MDT-PUDSP22005-R2-PUDSP Plan redlines.pdf Markup Summary

SP07
 SHEET 11 OF 31

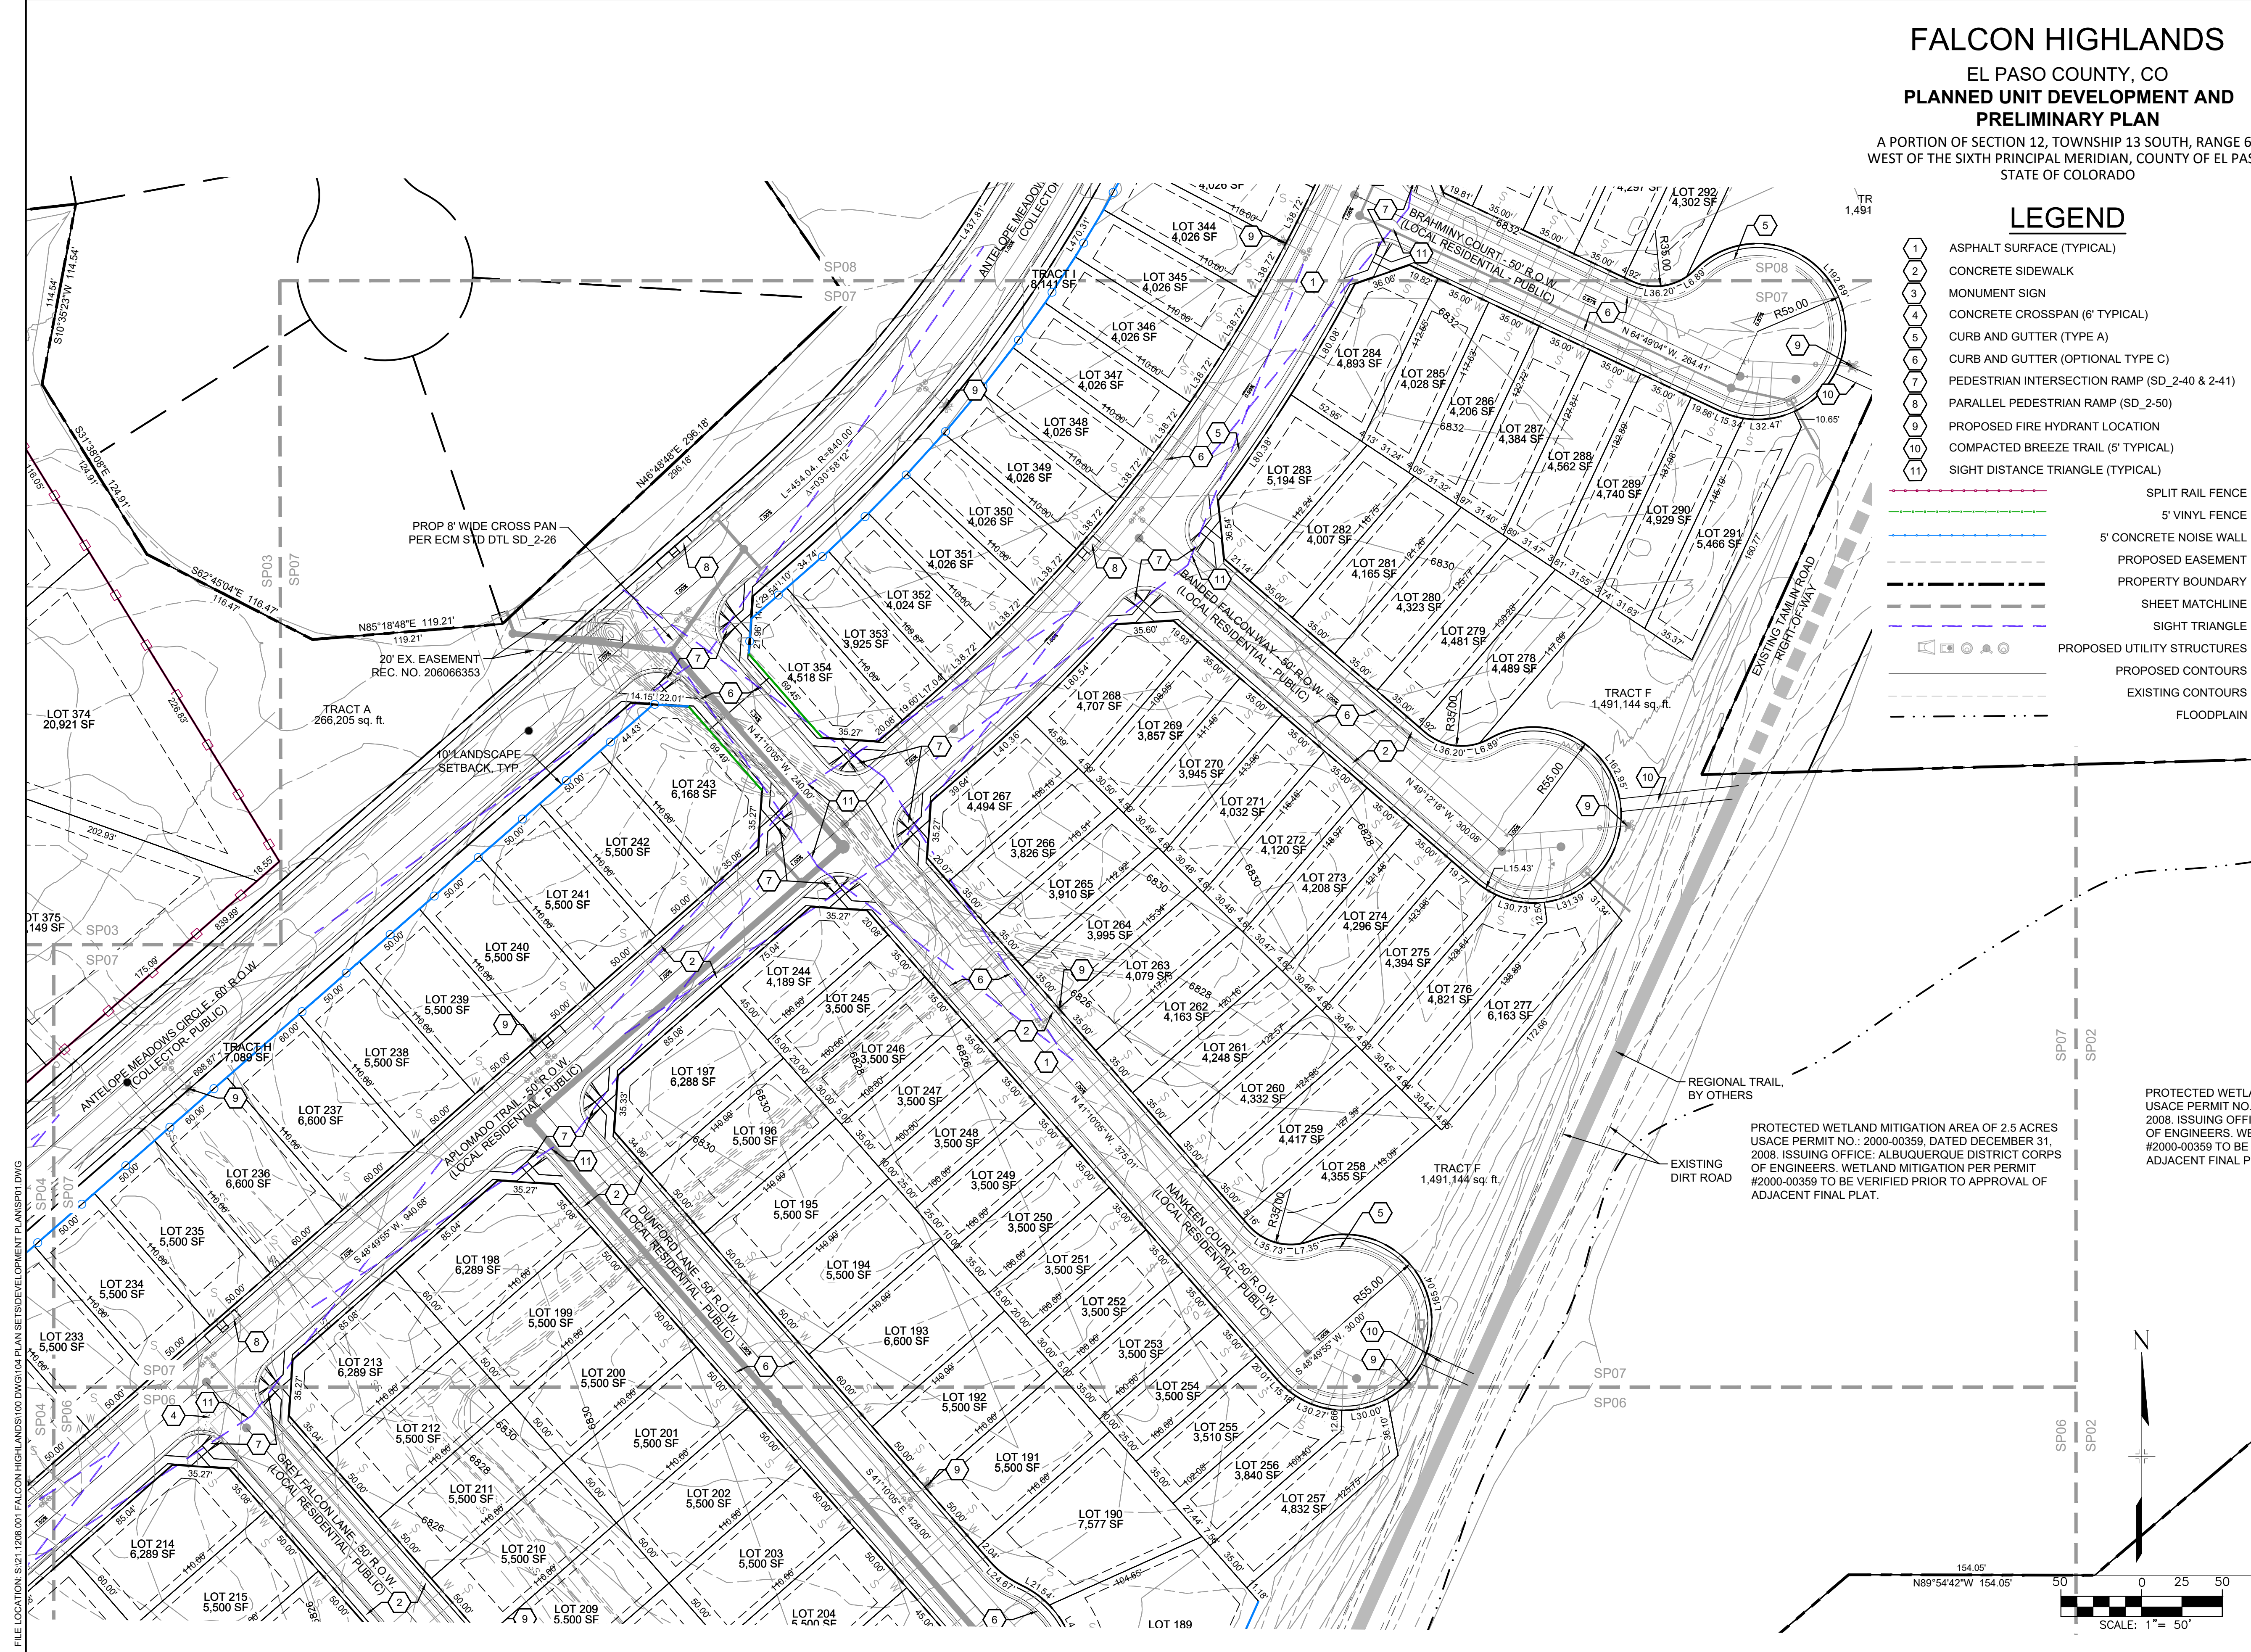
Unresolved review 1 comment:
show boundary with distances and bearings
